Drexel, Barrell & Co.

**RE: Letter of Intent & Justification Statement
Windermere
Preliminary Plan Amendment**

LOI V_3 redlines.pdf Markup Summary 12-10-2020

PP02

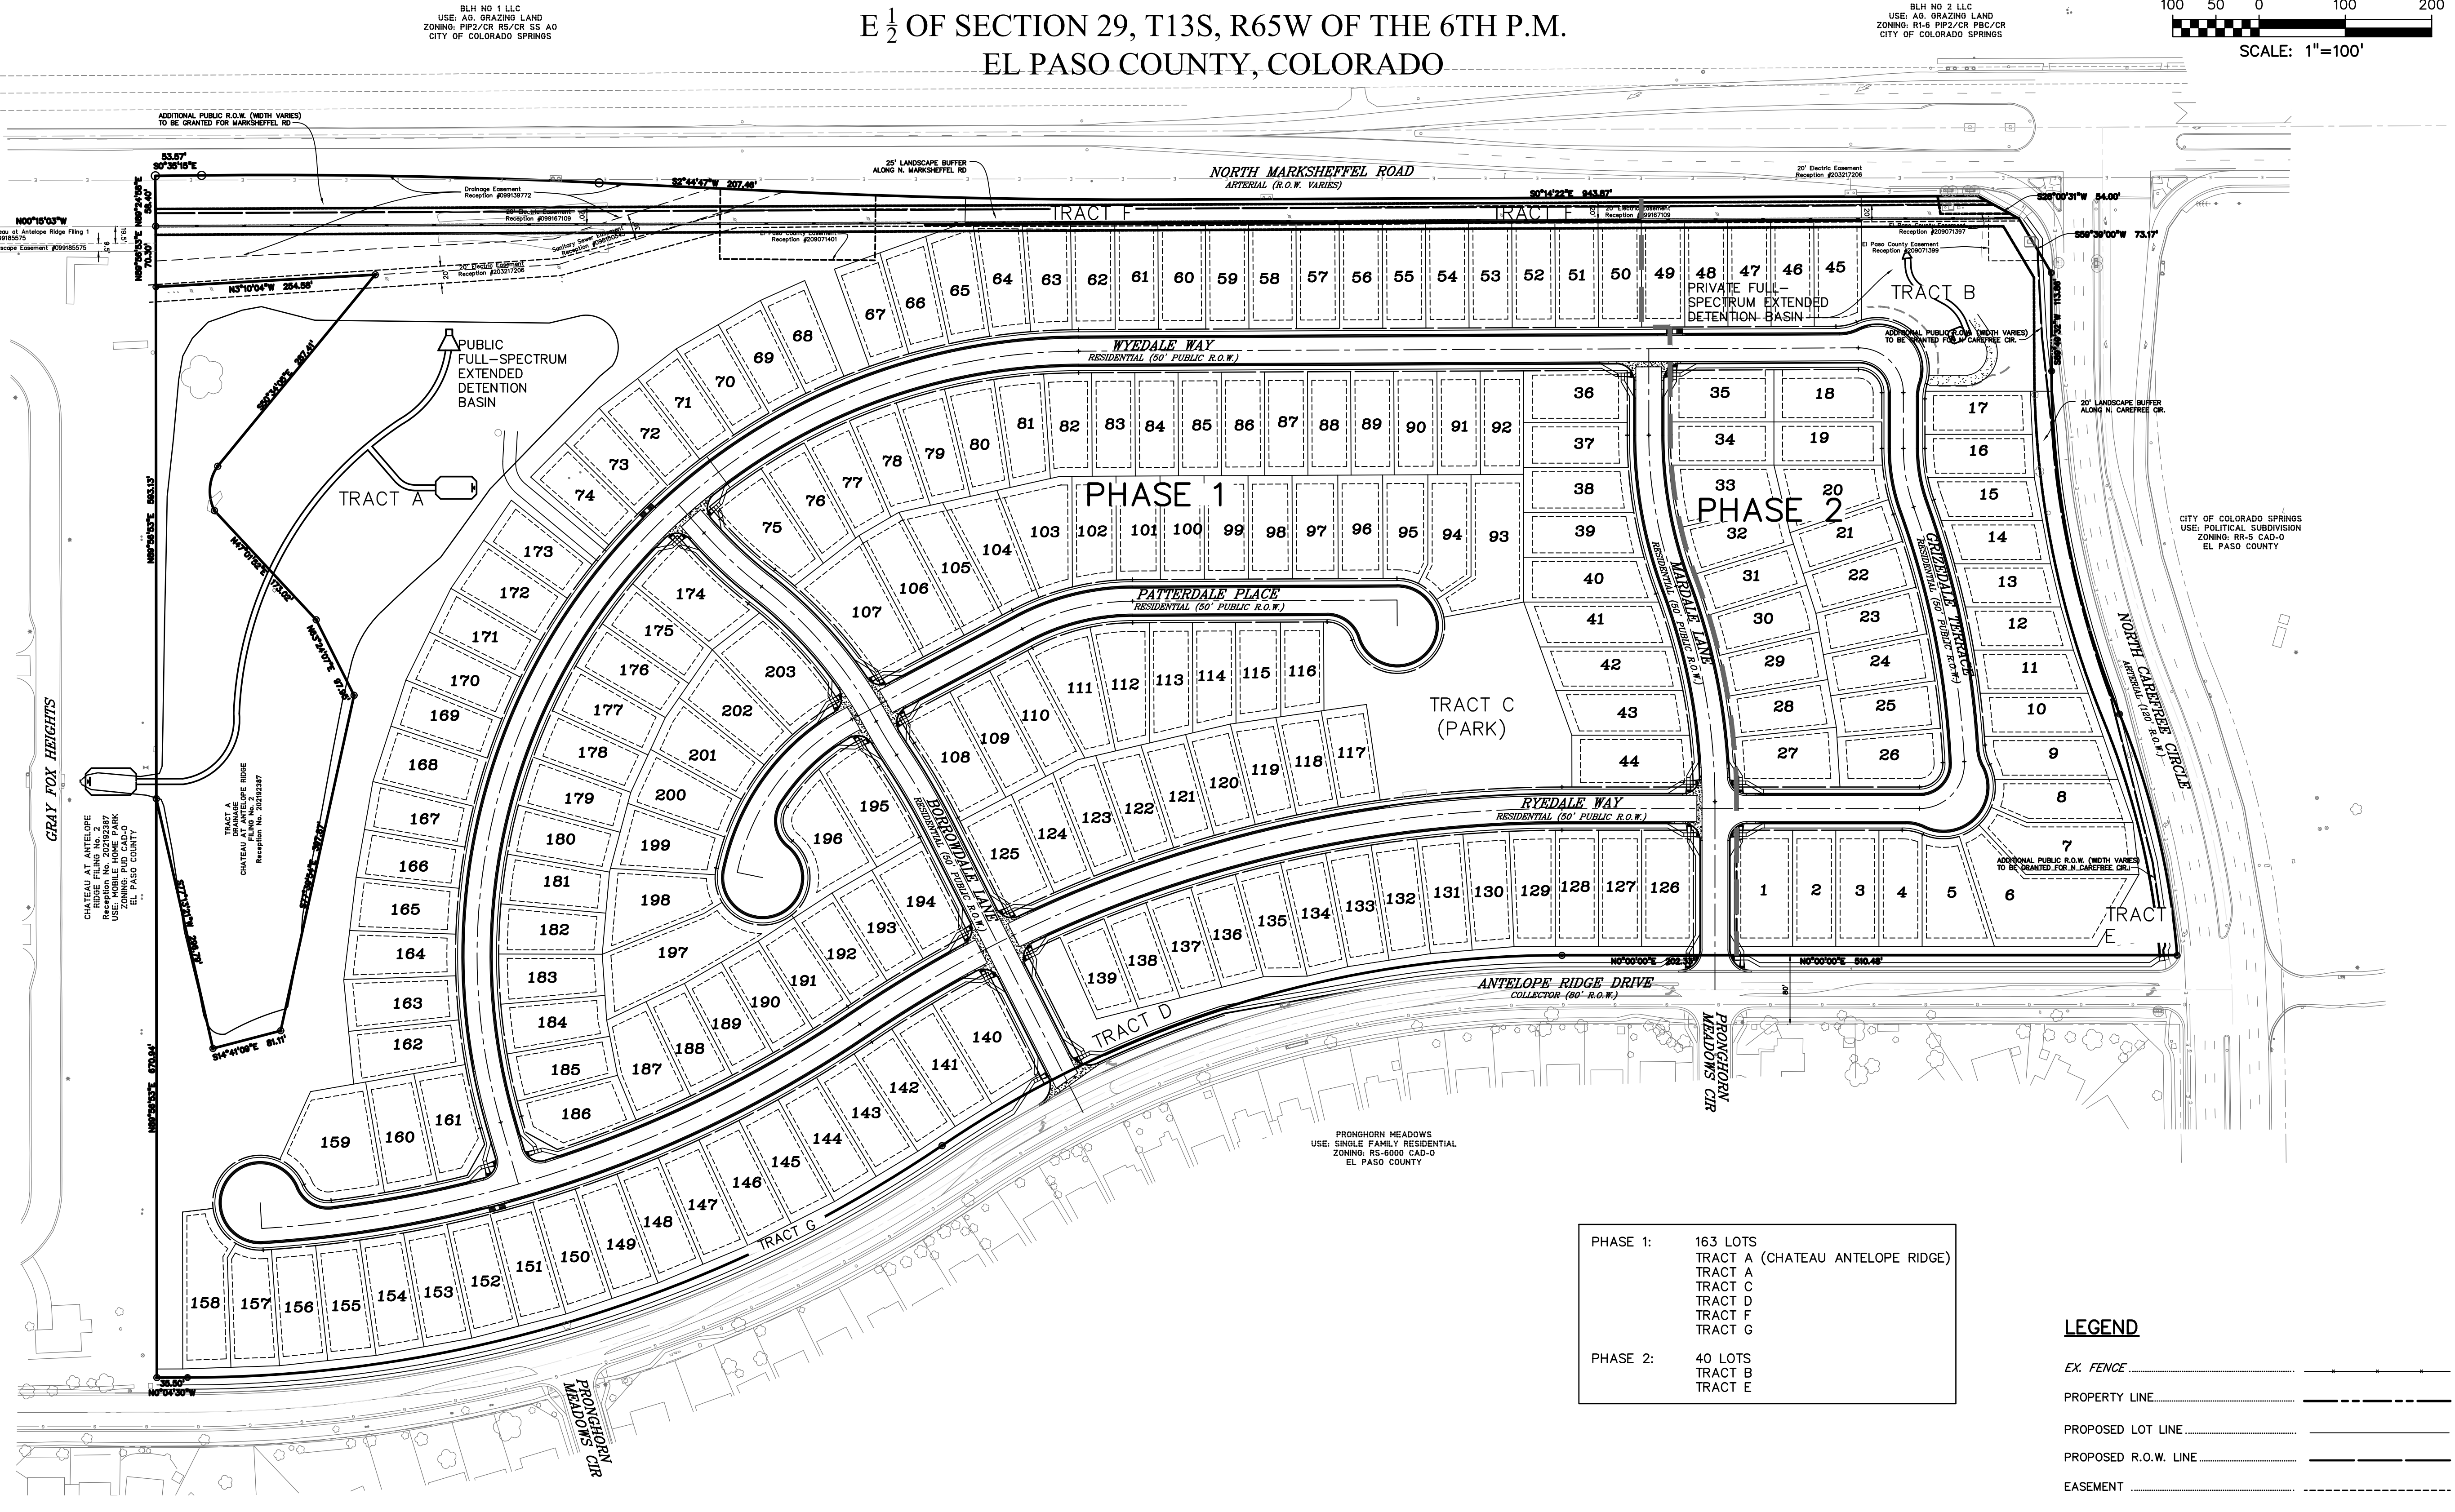
drainage is within tracts x, and z to be built with phase 1 by developer and maintained by ? District or HOA? ,

- PHASE 1: 163 LOTS
TRACT A (CHATEAU ANTELOPE RIDGE)
TRACT A
TRACT C
TRACT D
TRACT F
TRACT G
- PHASE 2: 40 LOTS
TRACT B
TRACT E

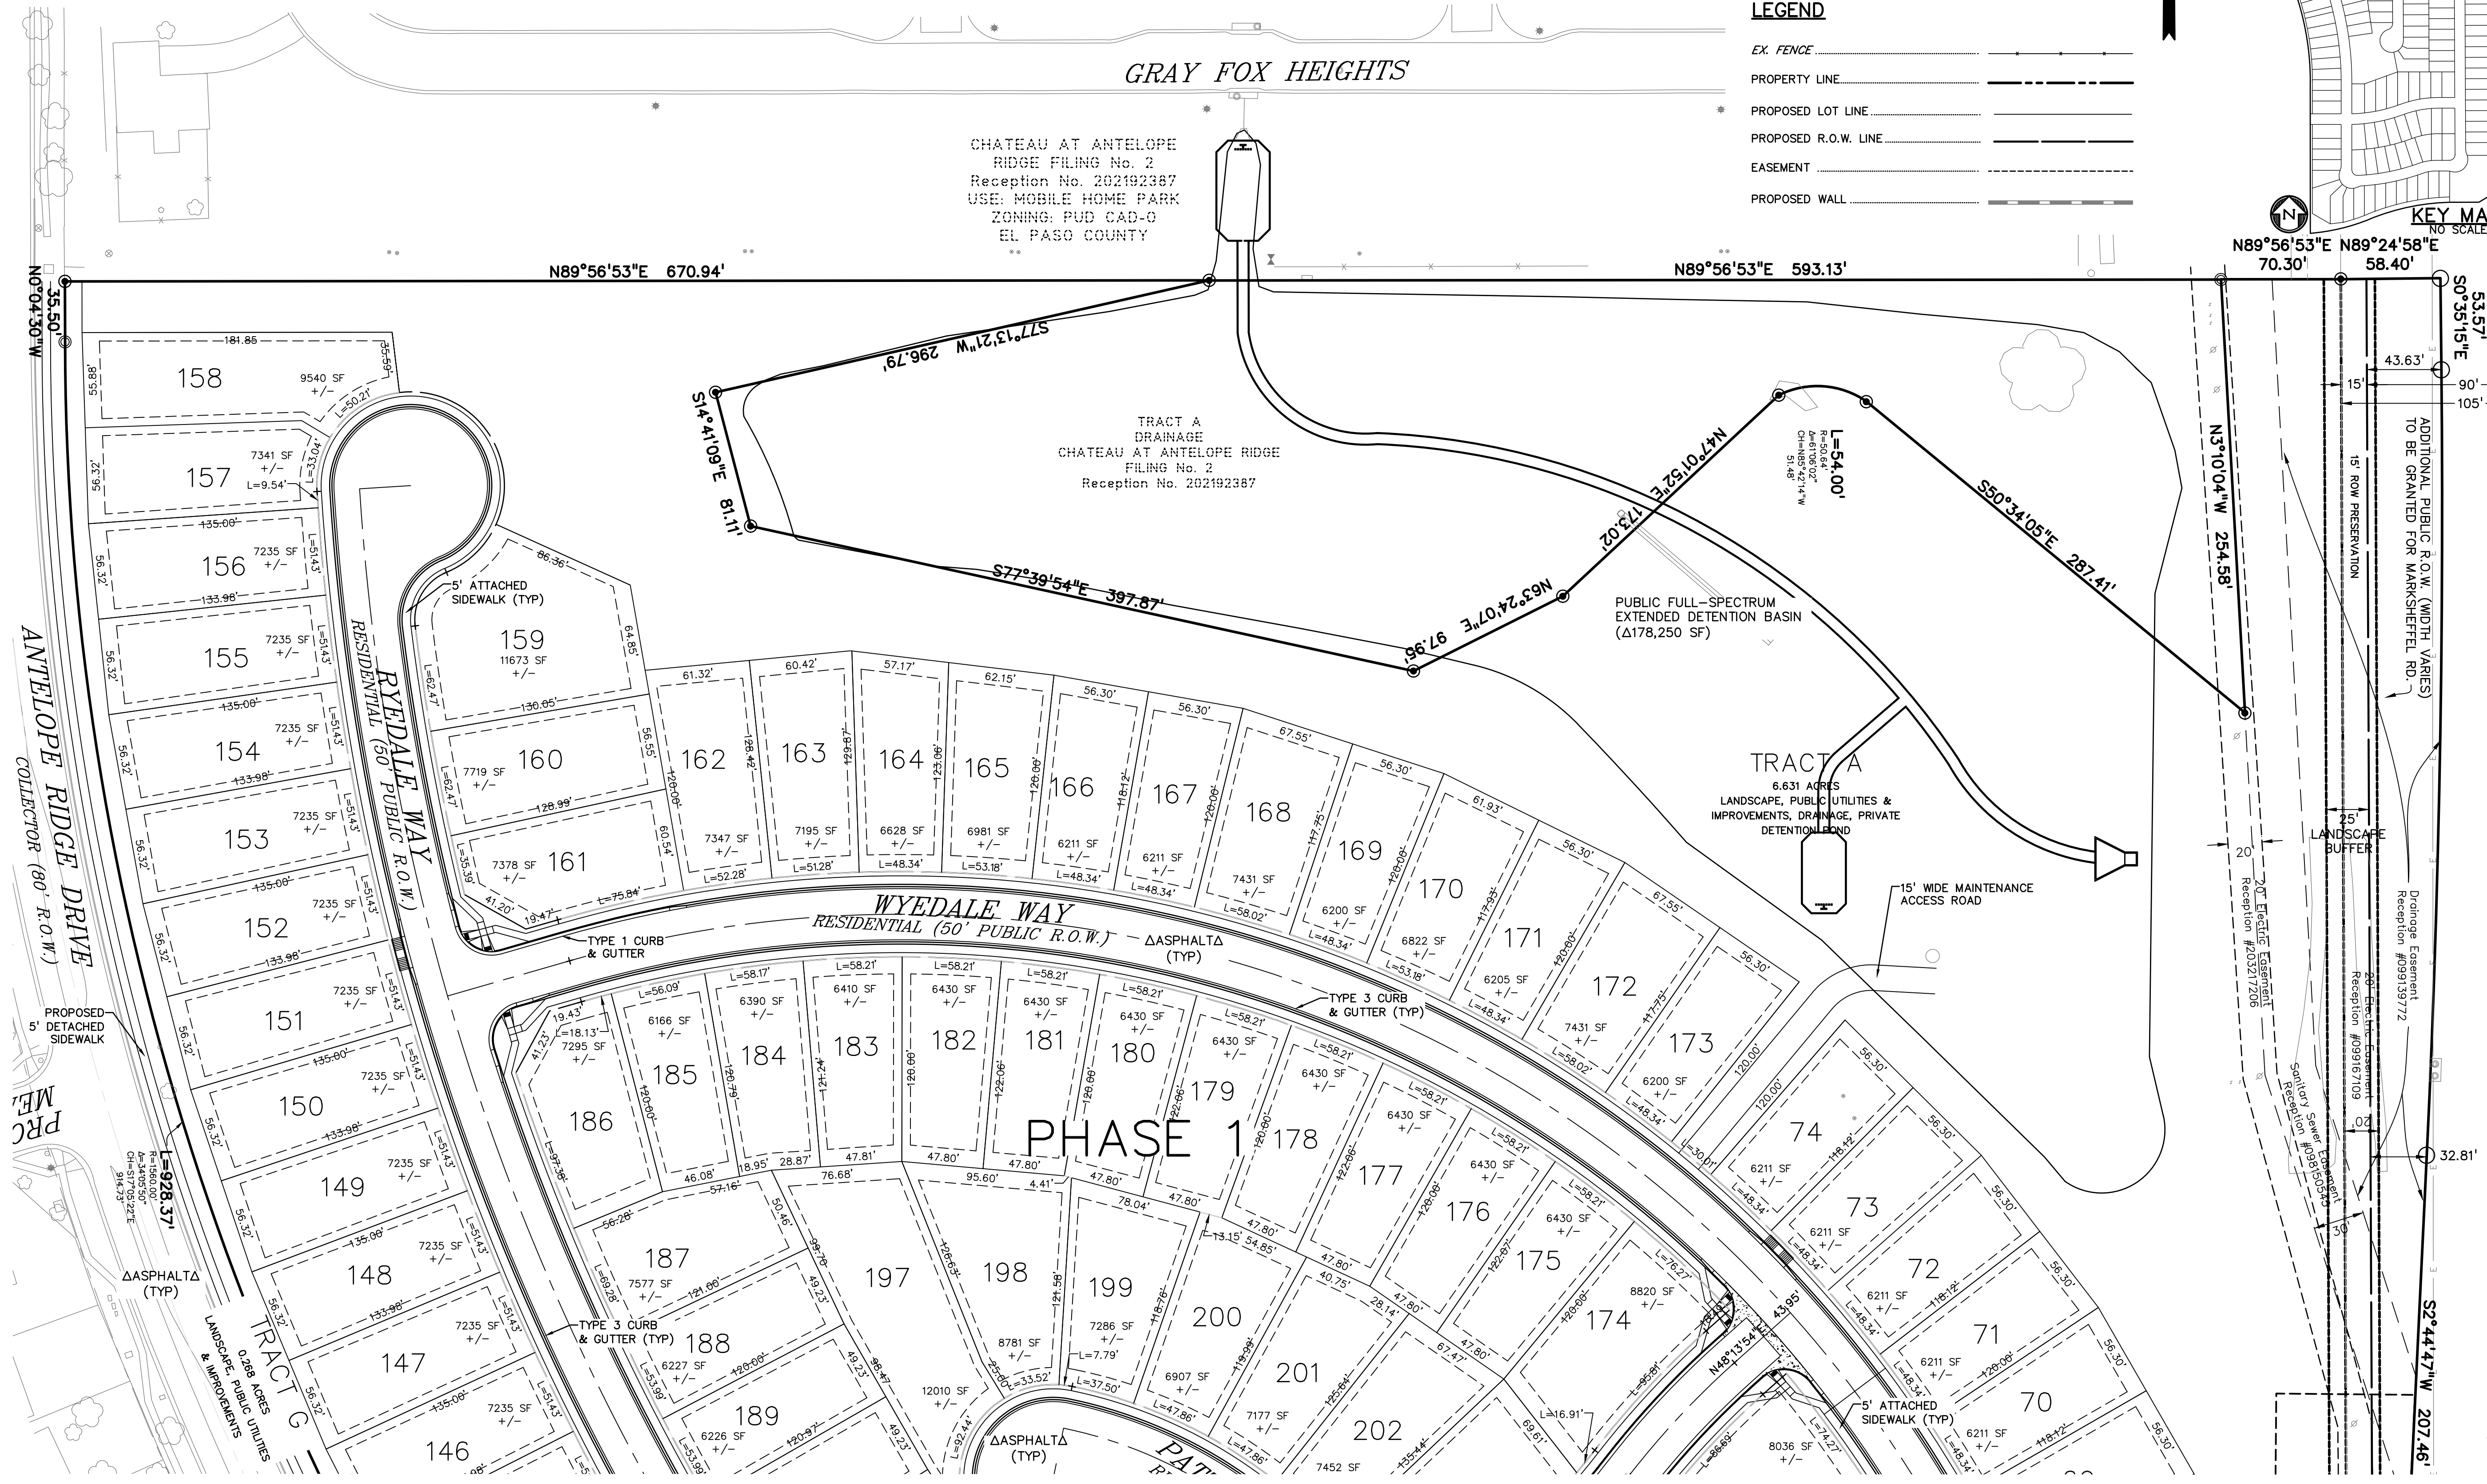
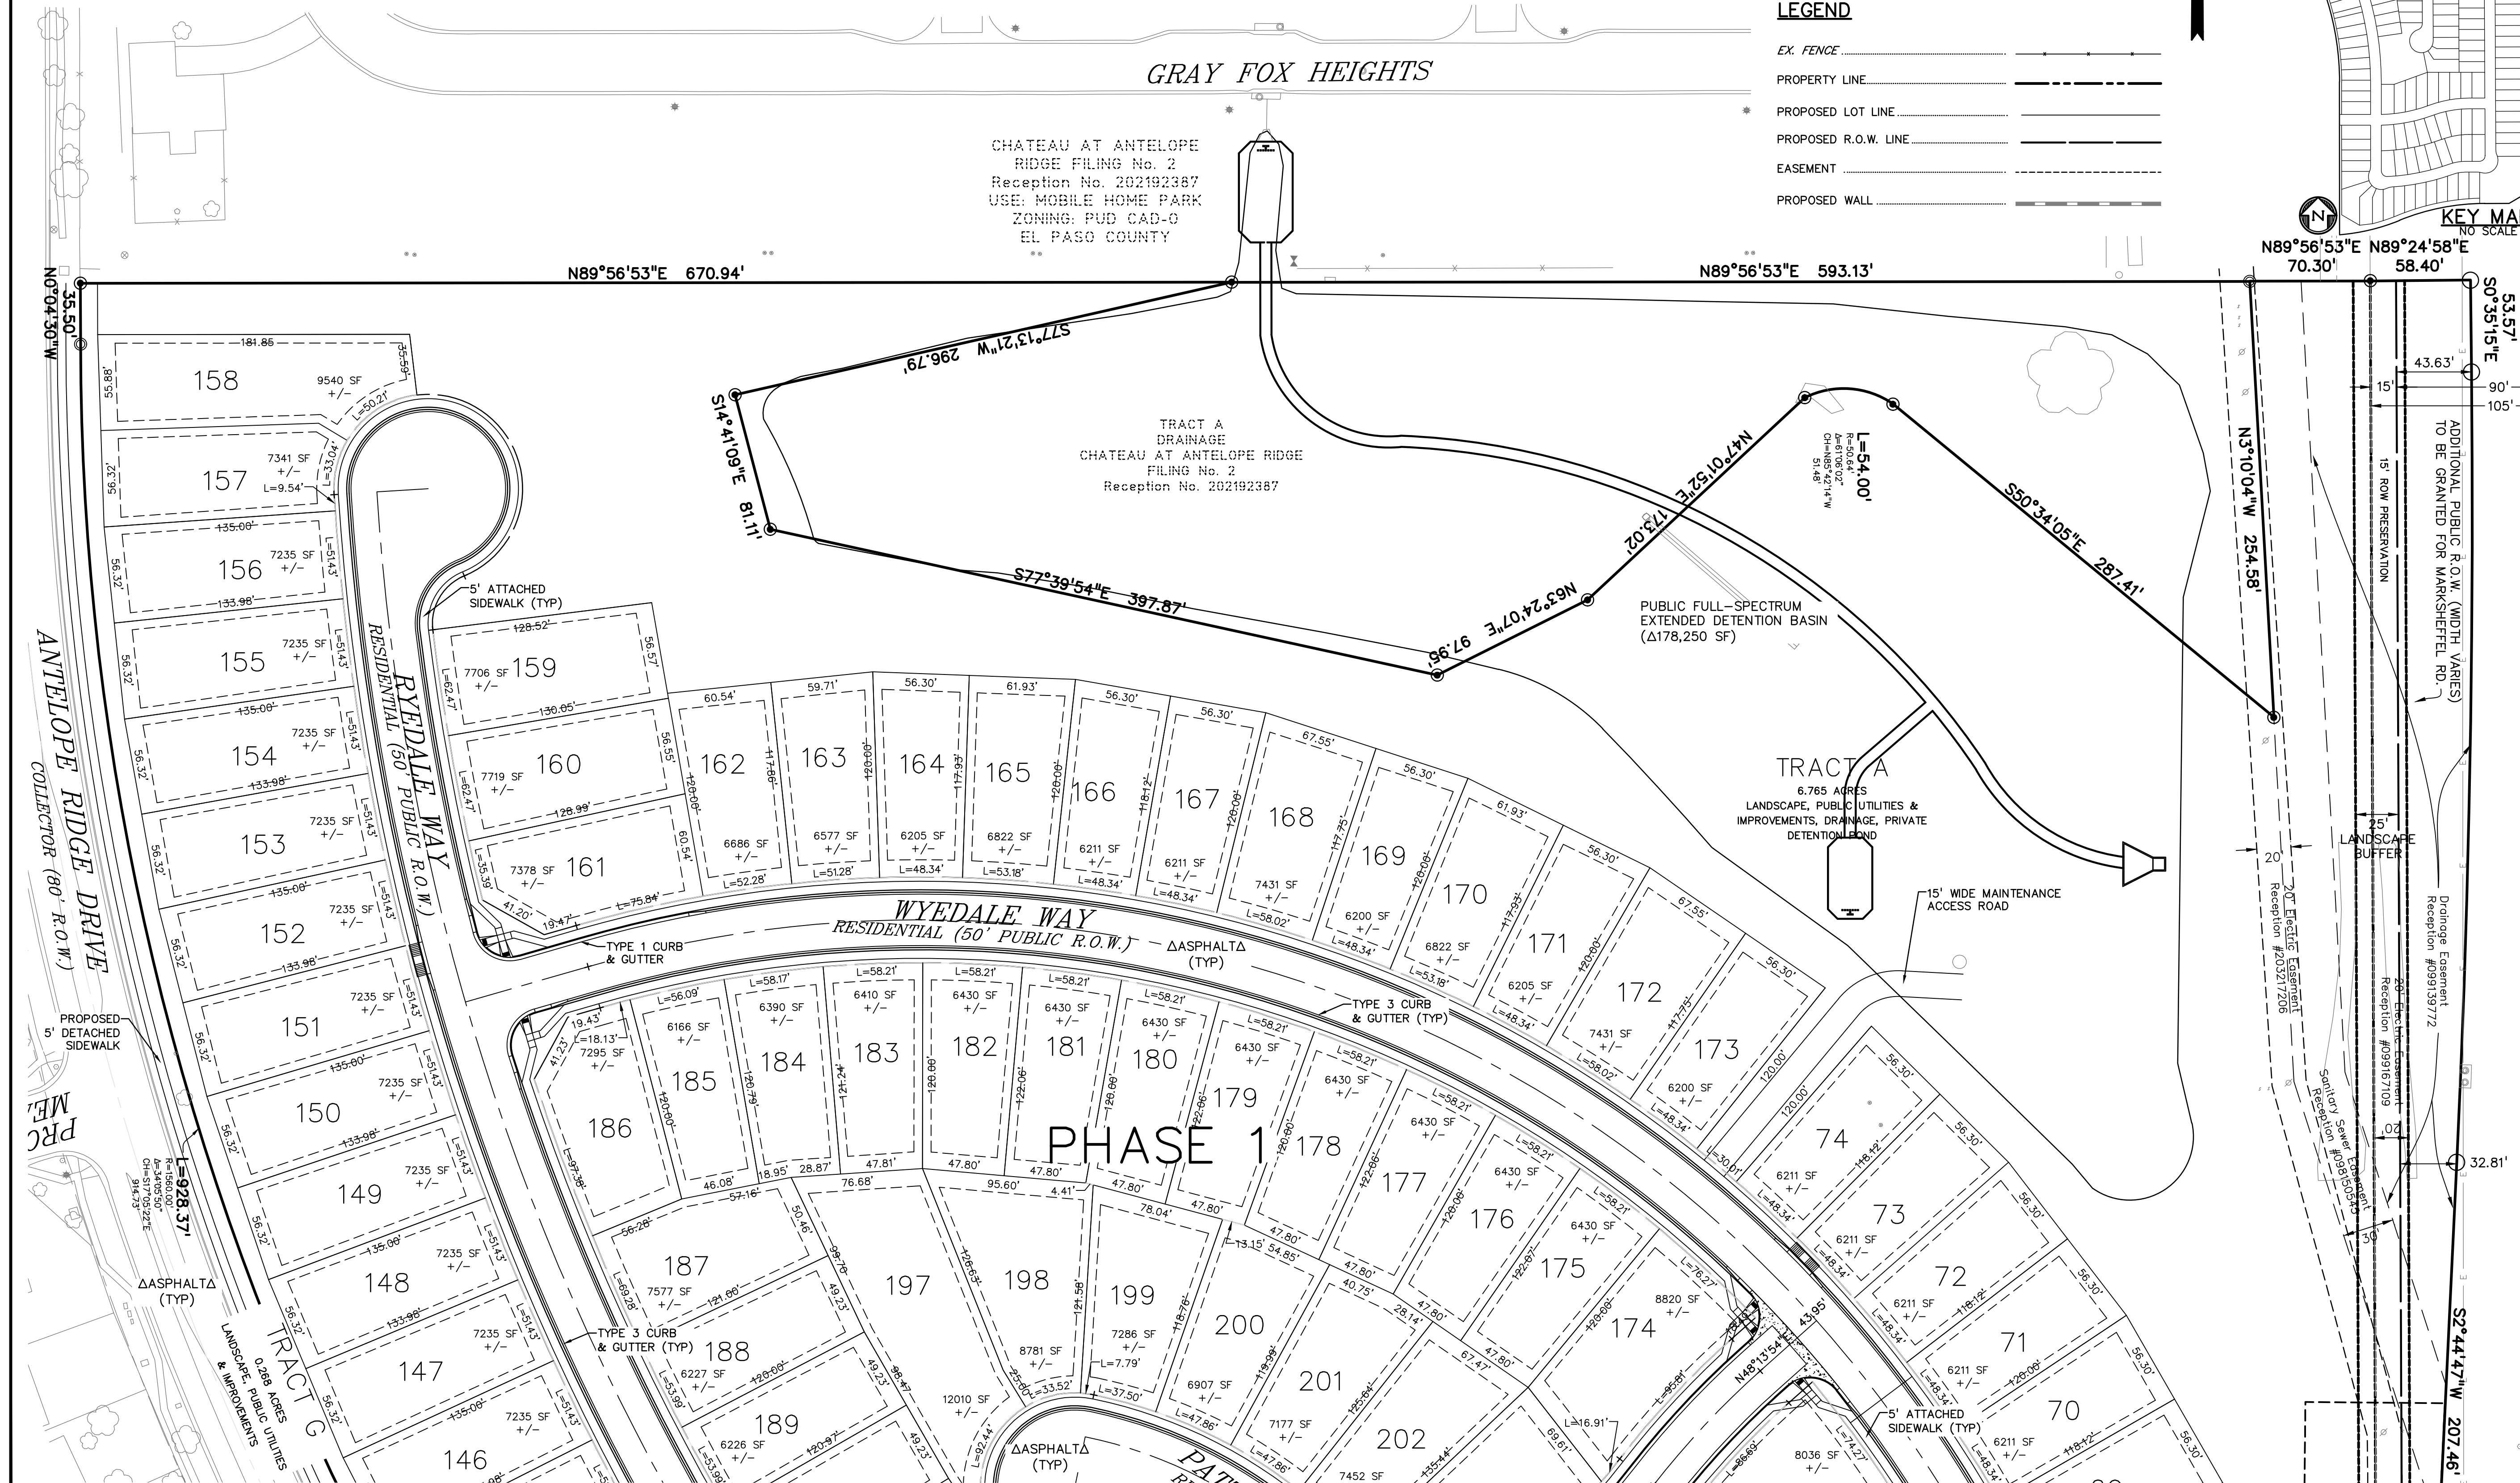
staff does have safety concerns with lack of buffer of the back yards against Marksheffel & Carefree Circle - no fencing to prevent a safety hazard 8.4.2 A.1

Staff has concerns with the majority of the noise above 65db on the site (some above 66.5)- the study conservative as it is completed in Feb 2019 will be resubmitted with updated noise data and T counts at plat; it is likely noise walls would be required along MarkSheffel and should be indicated on prelim plan. Carefree will also likely be studied at Plat. Please address this here as it will be in staff report.
